Application Ref:	3/2026/0661			 Ribble Valley Borough Council www.ribblevalley.gov.uk
Date Inspected:	N/A	Site Notice:	N/A	
Officer:	LOH			
DELEGATED ITEM FILE REPORT:				APPROVAL

Development Description:	Certificate of lawfulness for proposed single storey rear extension.
Site Address/Location:	Sandilands Farm, Rimington Lane, Rimington, BB7 4DS

SHEET: PROPOSED ELEVATIONS

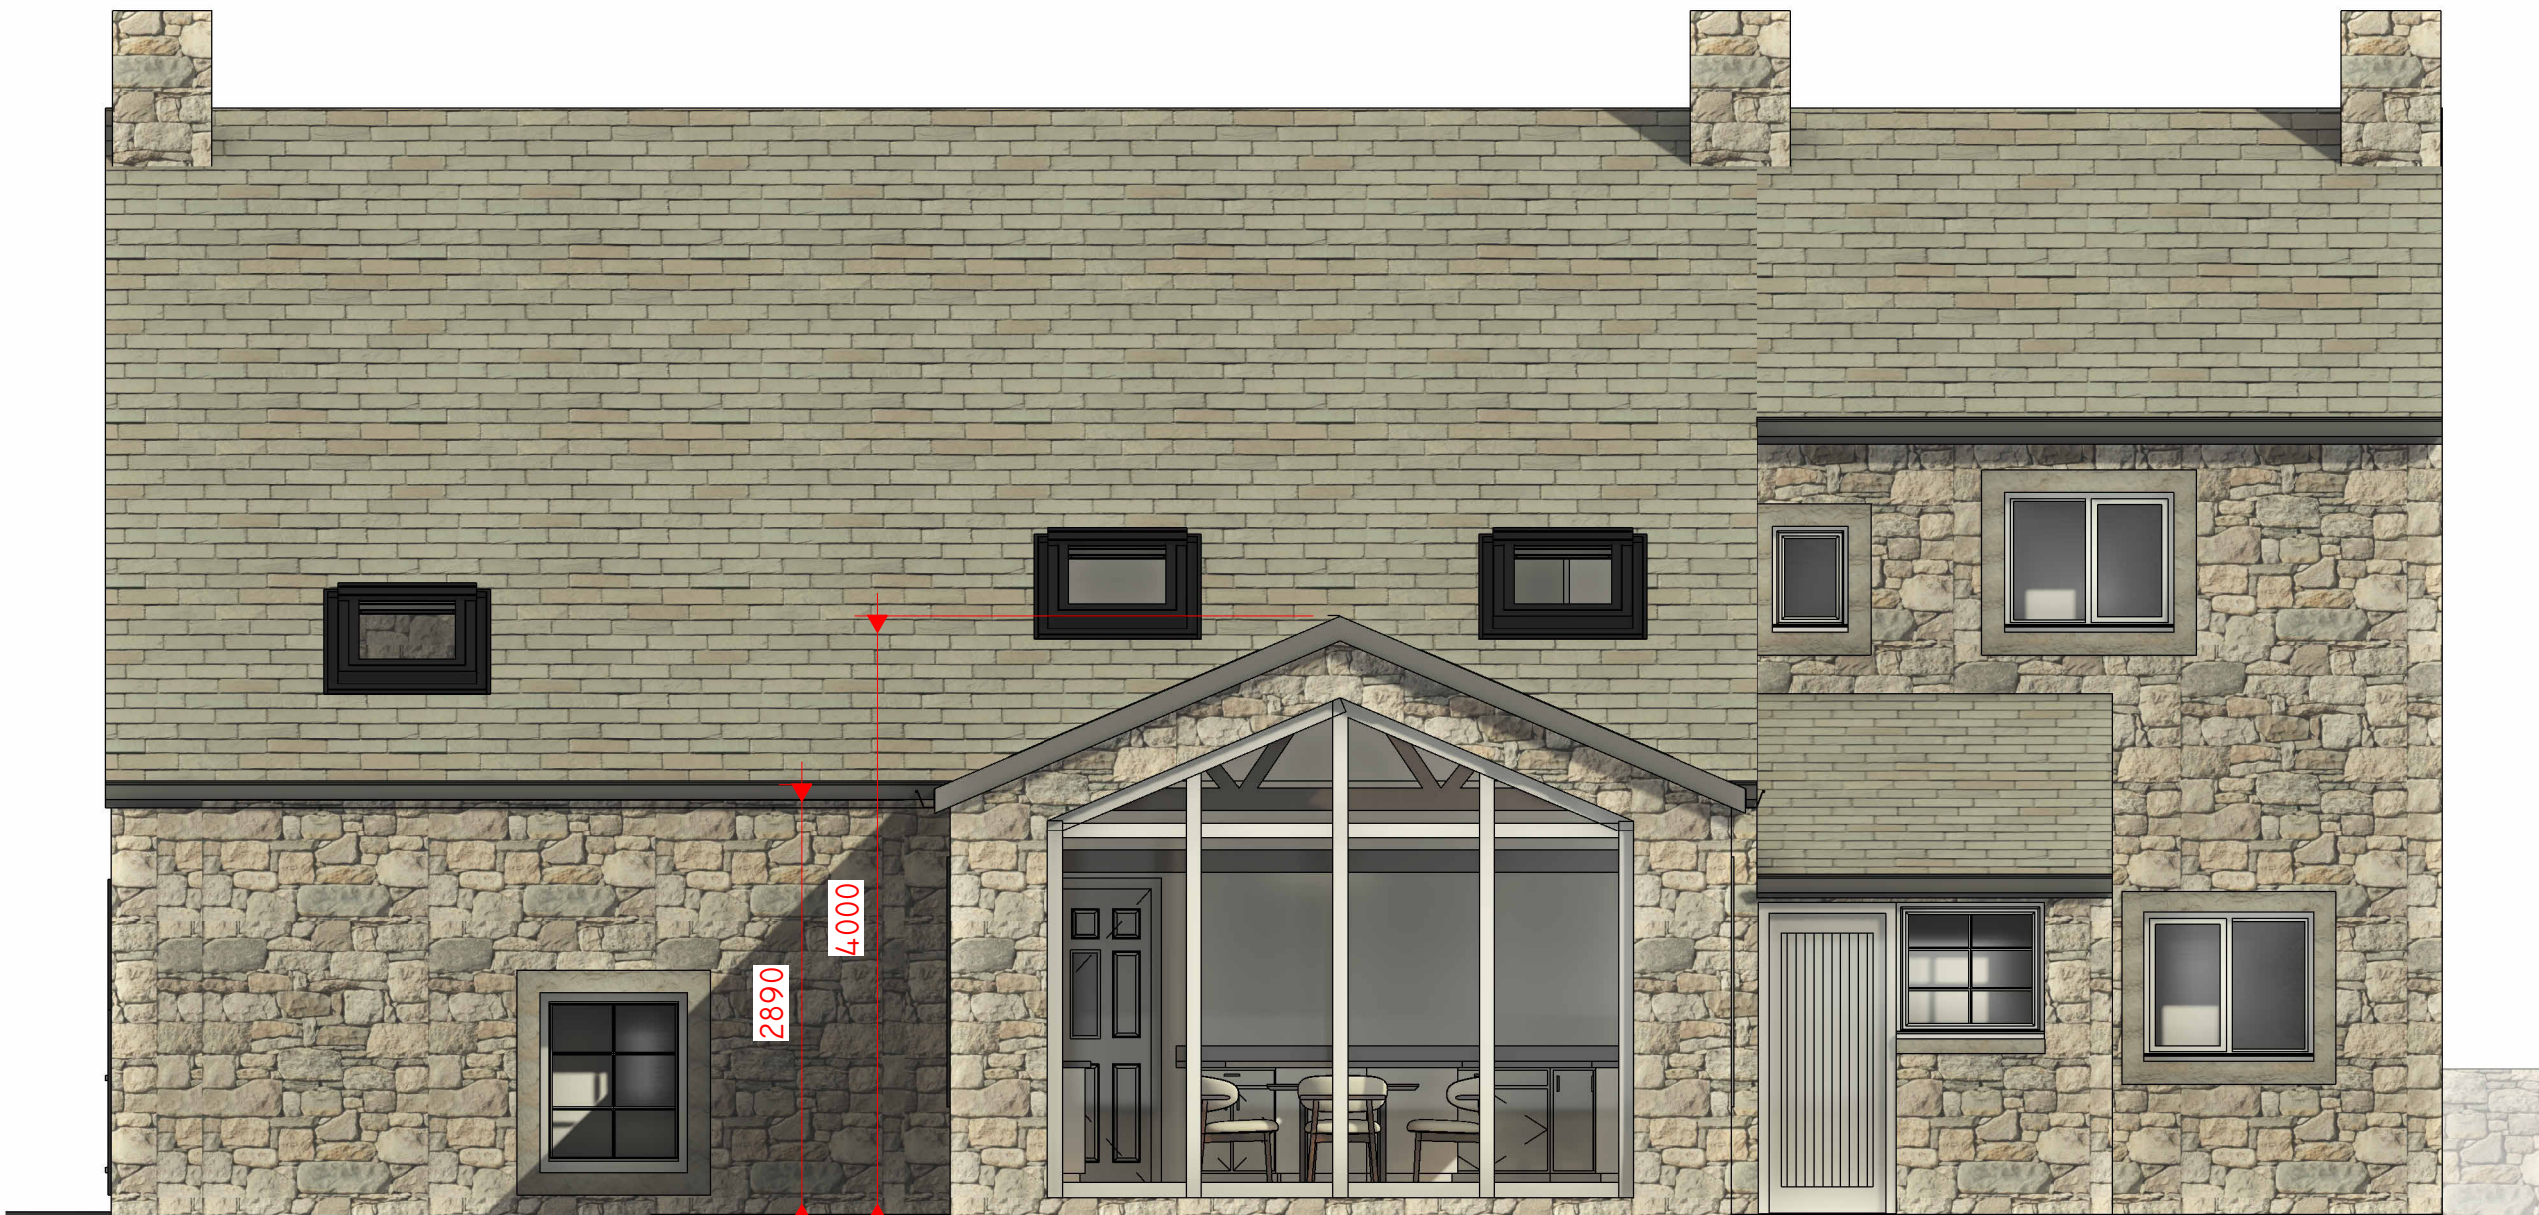
The proposed extension would feature a pitched roof with eaves and ridge height of 2.8m and 4m respectively and incorporate 4 roof lights. The proposal also features glazing to the northwest facing elevation, and 4 windows on the northeast and southwest elevations.

The height of the proposed single storey extension would not exceed the height of the highest part of the roof of the existing dwellinghouse.

The height of the eaves of the proposed extension would not exceed the height of the eaves of the existing dwellinghouse.

The proposed extension would have a single storey and would not extend beyond the rear wall of the original dwellinghouse by more than 4m or exceed 4m in height.

The enlarged part of the dwellinghouse would not be within 2m of the boundary of the curtilage of the dwellinghouse, and the height of the eaves of the enlarged part would not exceed 3m.

1 0 PROPOSED GROUND FLOOR
1 : 50

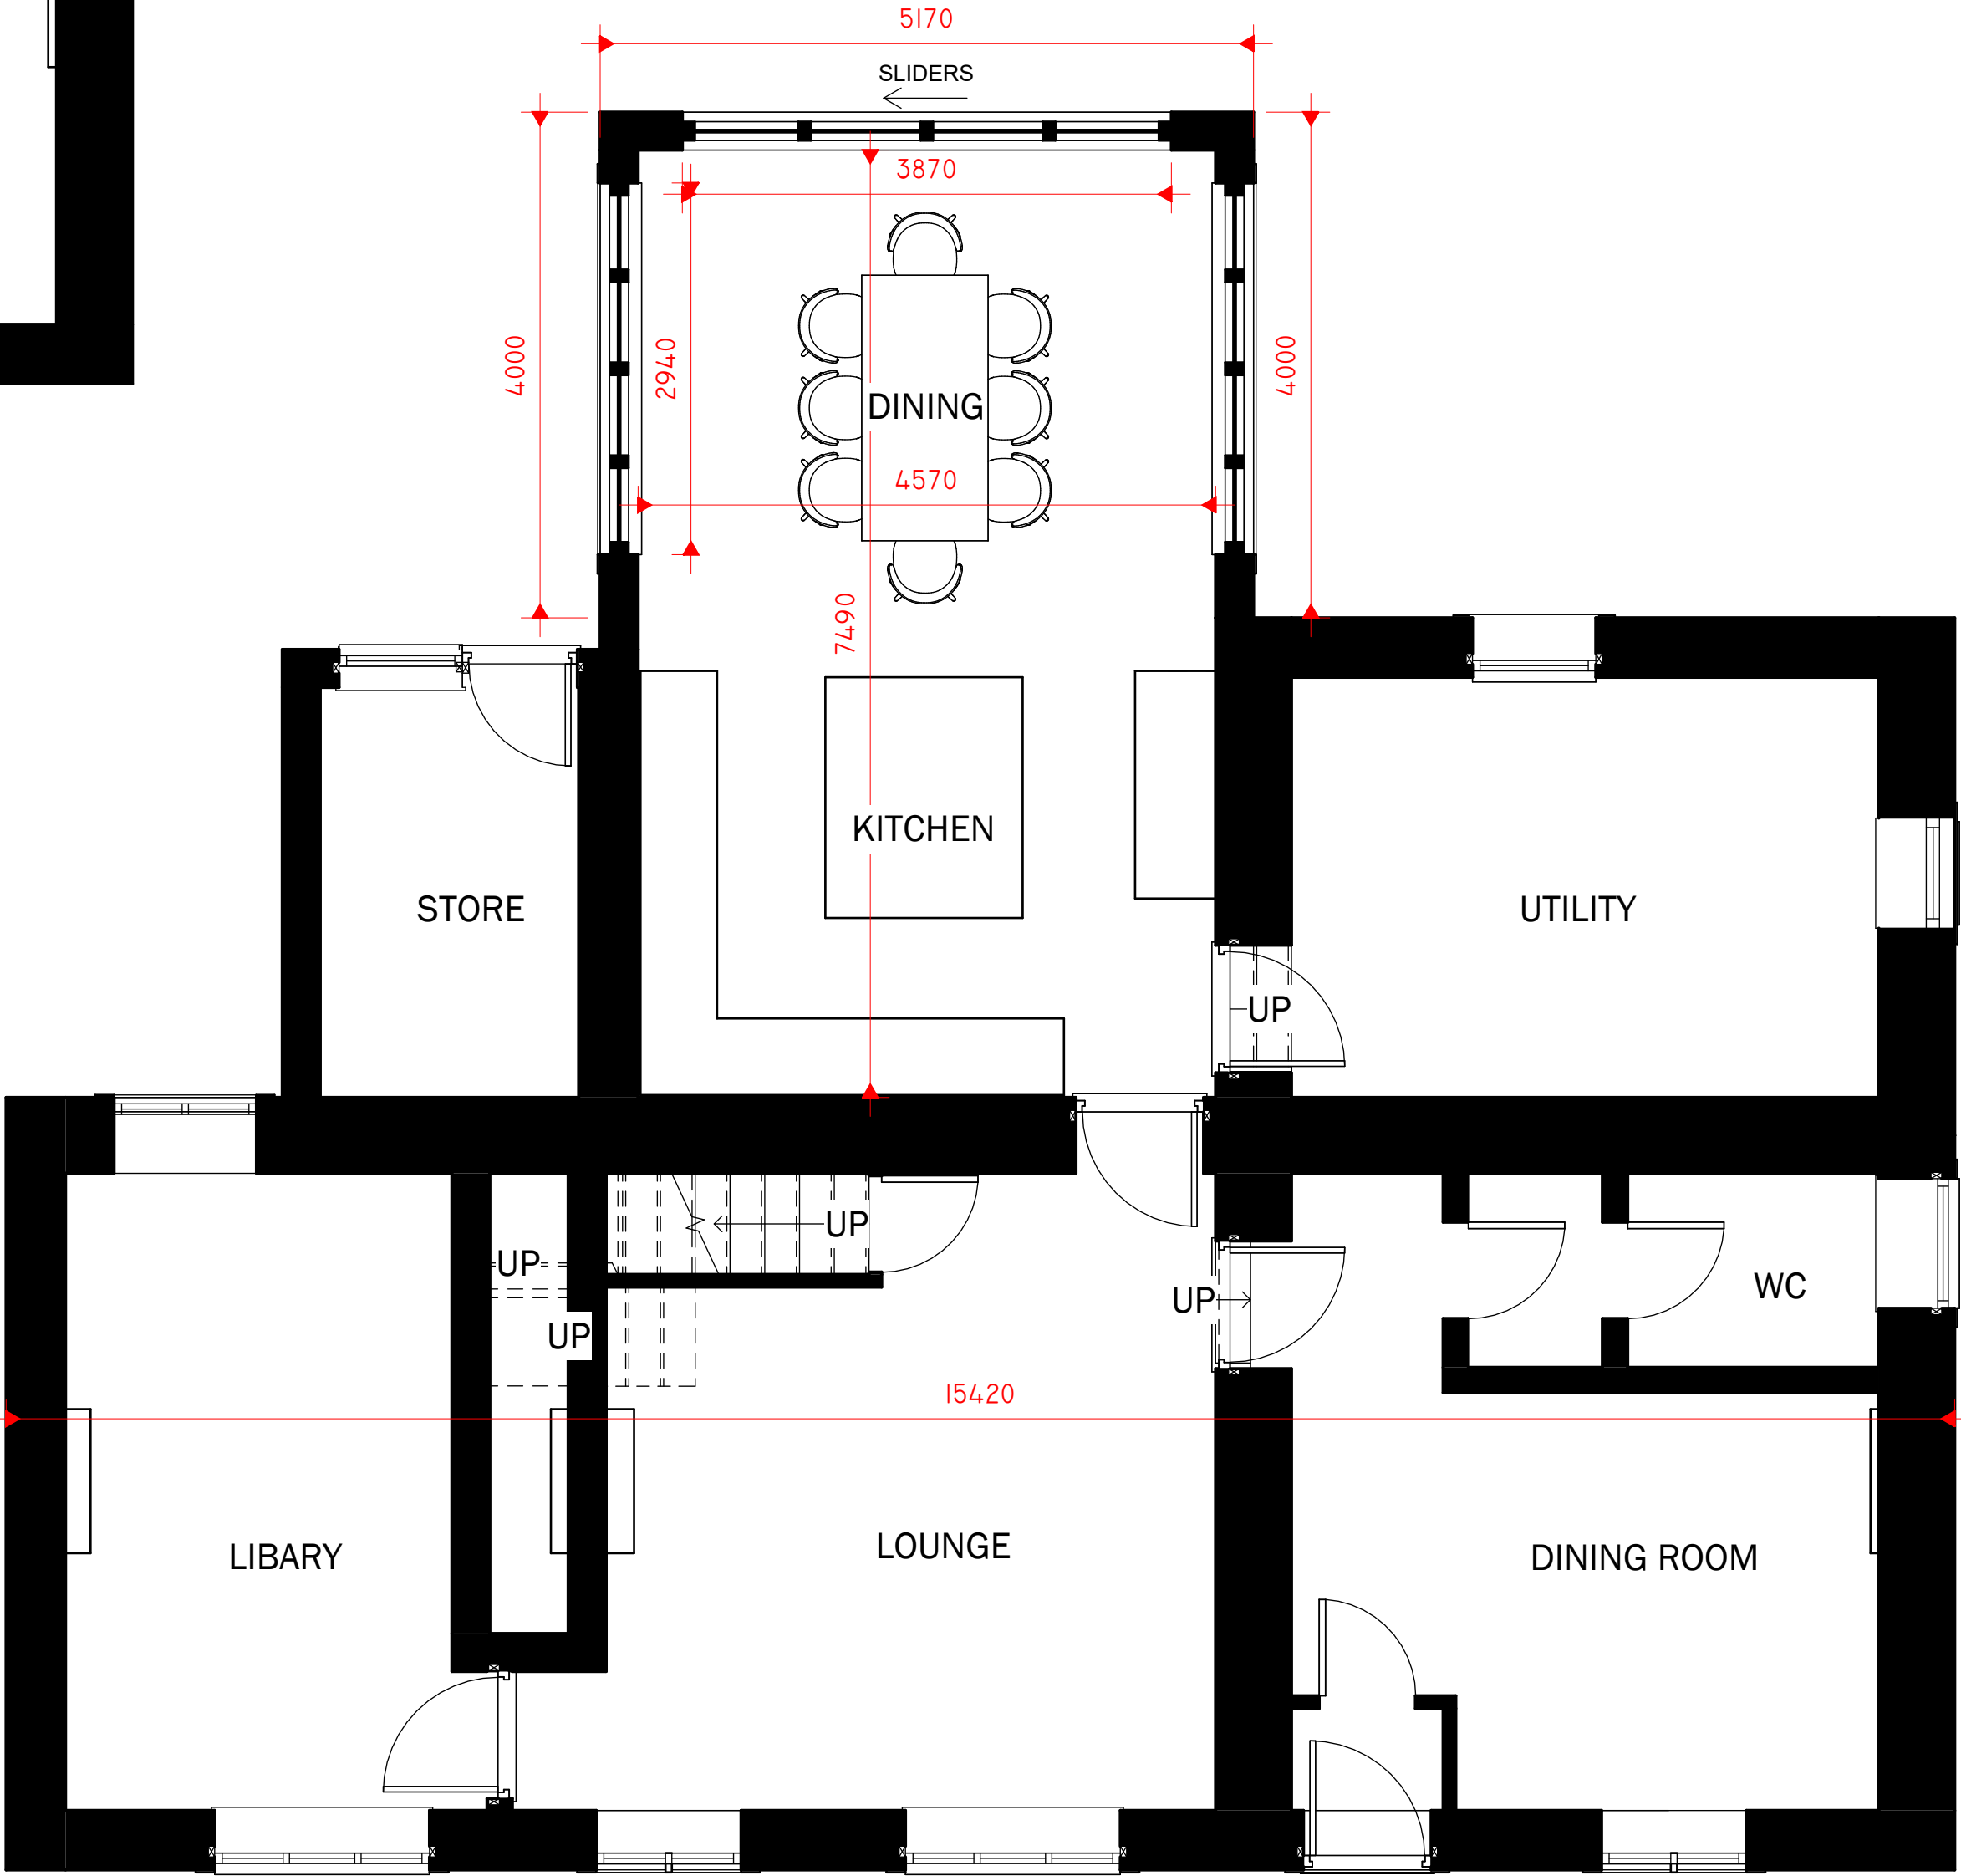
Consent is sought for a certificate of lawfulness for the construction of a proposed single storey rear extension, projecting 4 metres from the rear elevation of the existing dwellinghouse with a width of 5.1 metres.

The proposed extension would not exceed 50% of the total area of the curtilage of the property.

The proposed extension would not extend beyond a wall which forms the principal elevation of the original dwellinghouse or front a highway and form a side elevation of the original dwellinghouse.

The enlarged part of the dwellinghouse would not extend beyond a wall forming a side elevation of the original dwellinghouse.
